# Rezoning Transportation Analysis

Petition Number: 2021-094

## Revision Log:

Date	Description
08-25-2021	First Review (LH)
09-17-2021	Second Review (WB)

RZ1.0

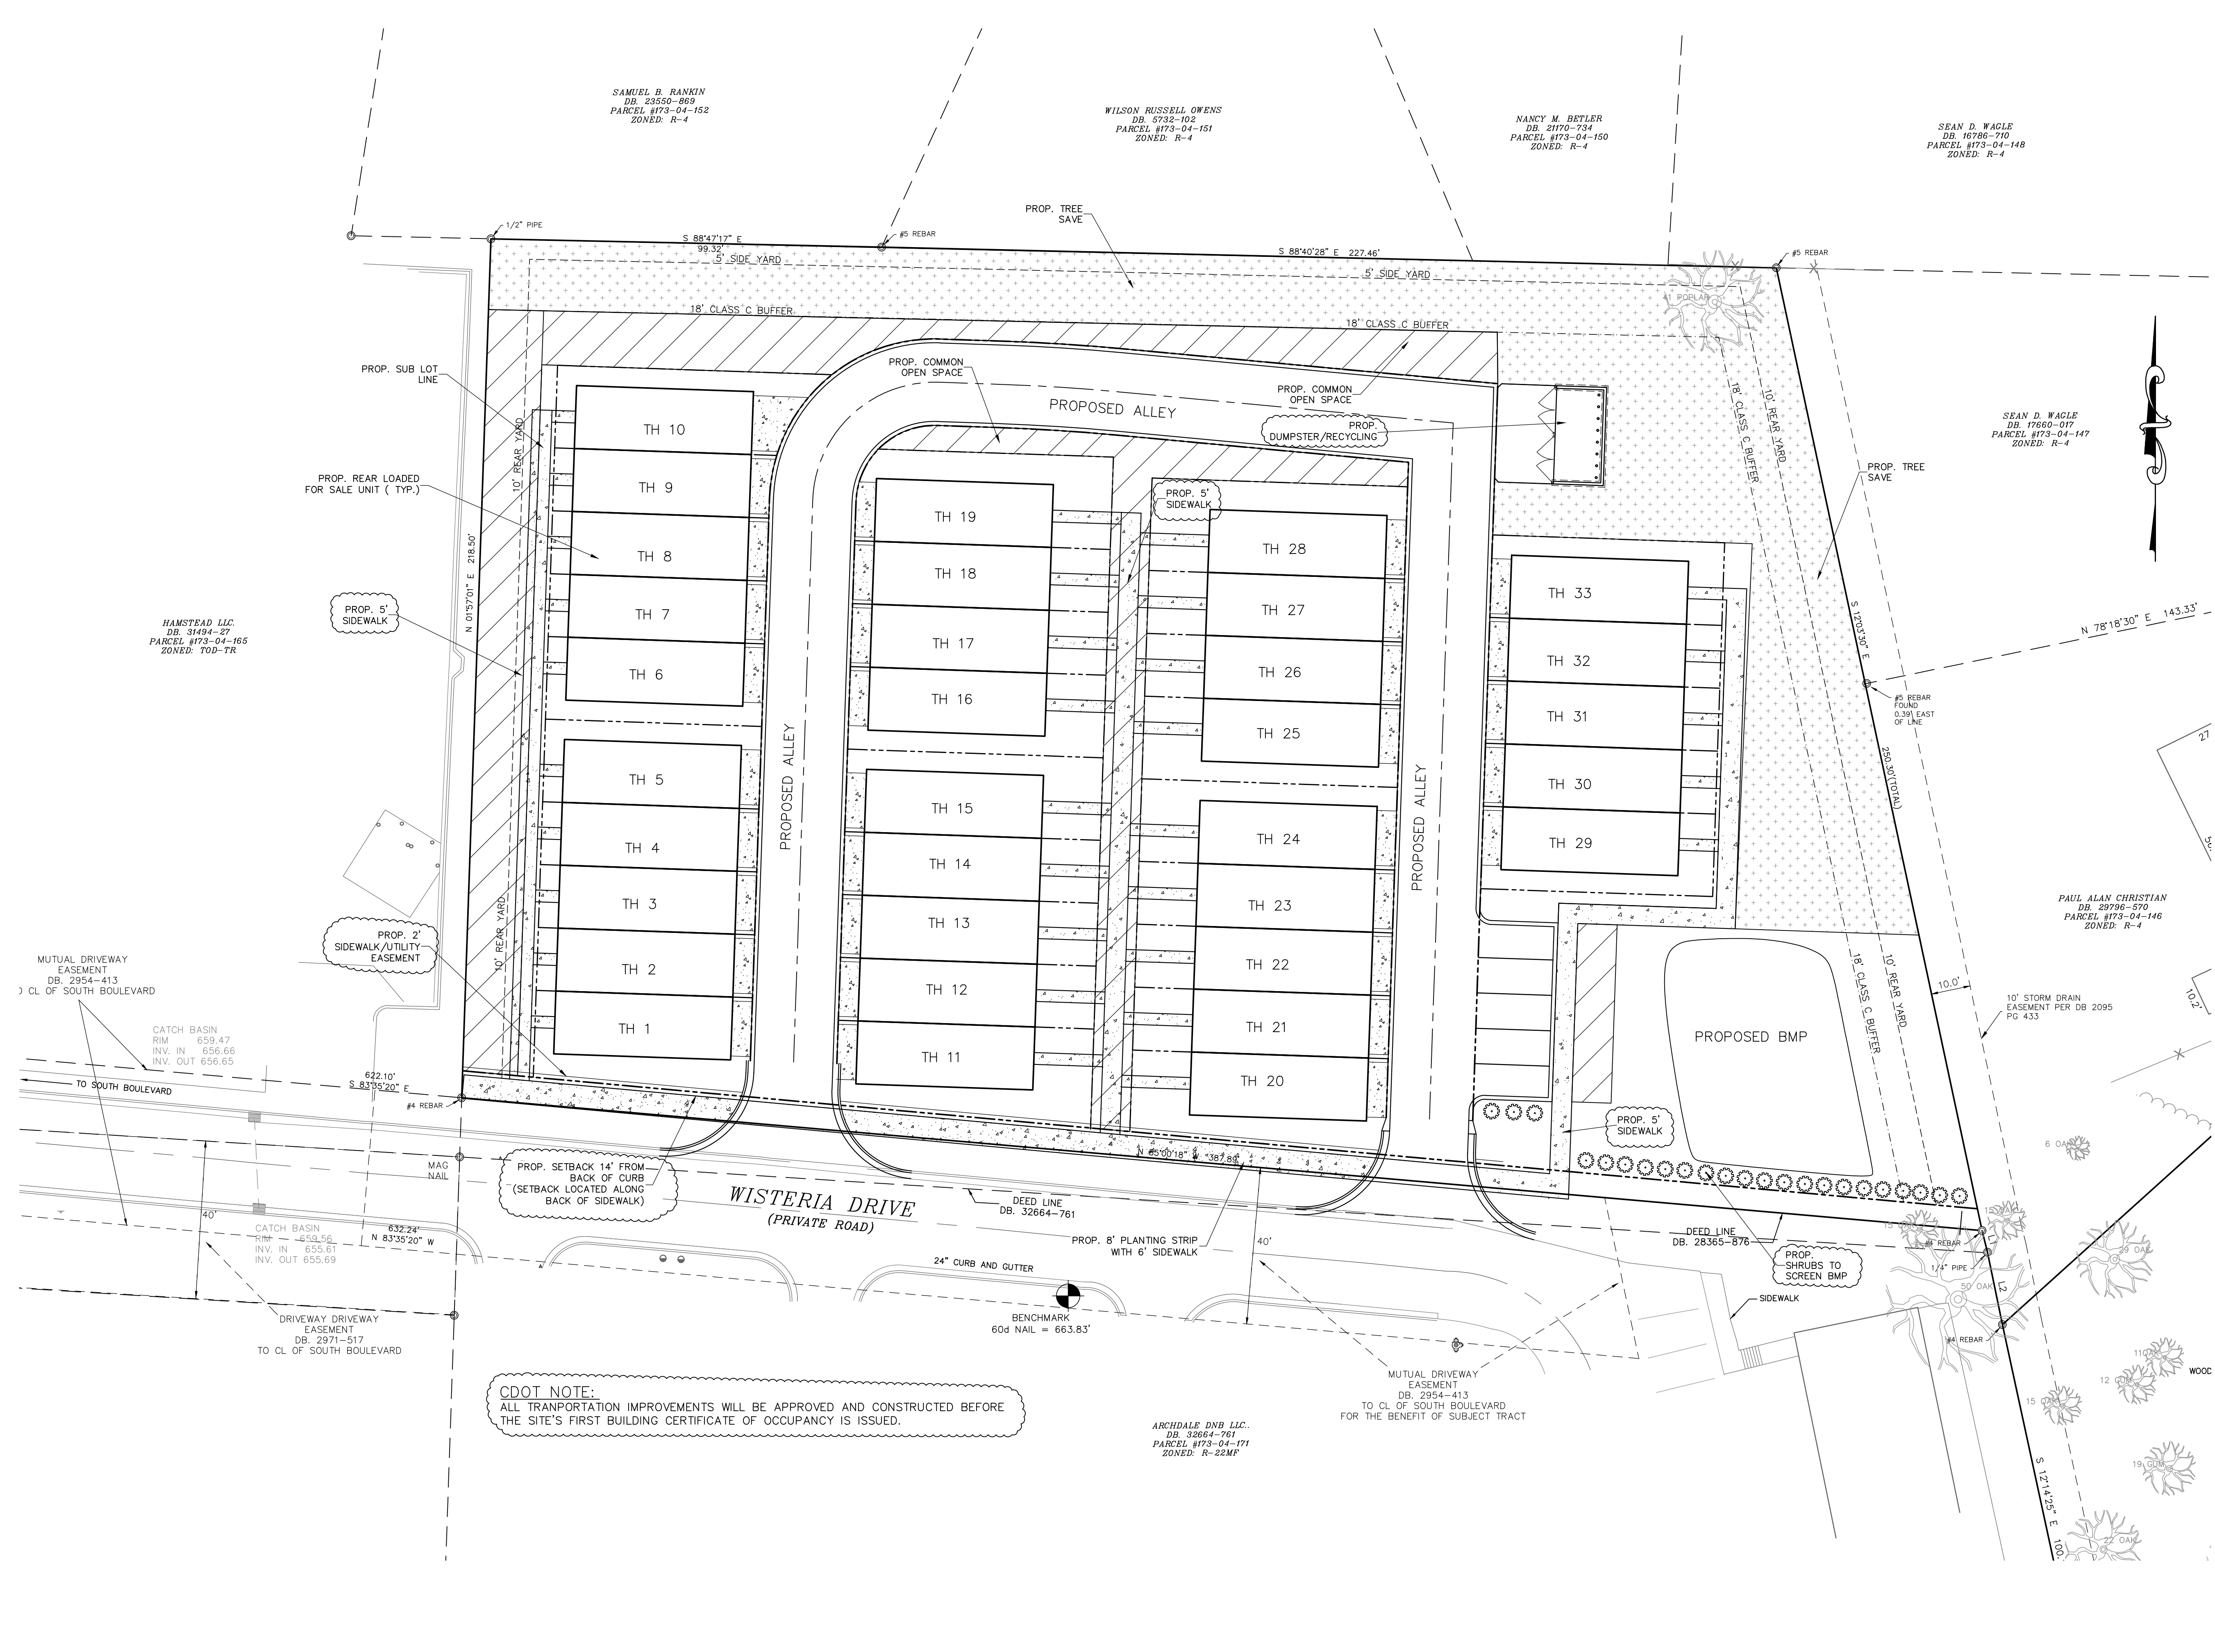
- ~~3. **Revised Site Plan Conditional Note E. Streetscape and Landscaping (2)** for the sidewalk utility easement to include 2' behind back of sidewalk, where feasible.~~

- ~~4. A site plan note specifying that all transportation improvements will be approved and constructed before the site's first building certificate of occupancy is issued is needed. The petitioner may phase transportation improvements if said improvements and phasing are explicitly described in site plan notes.~~
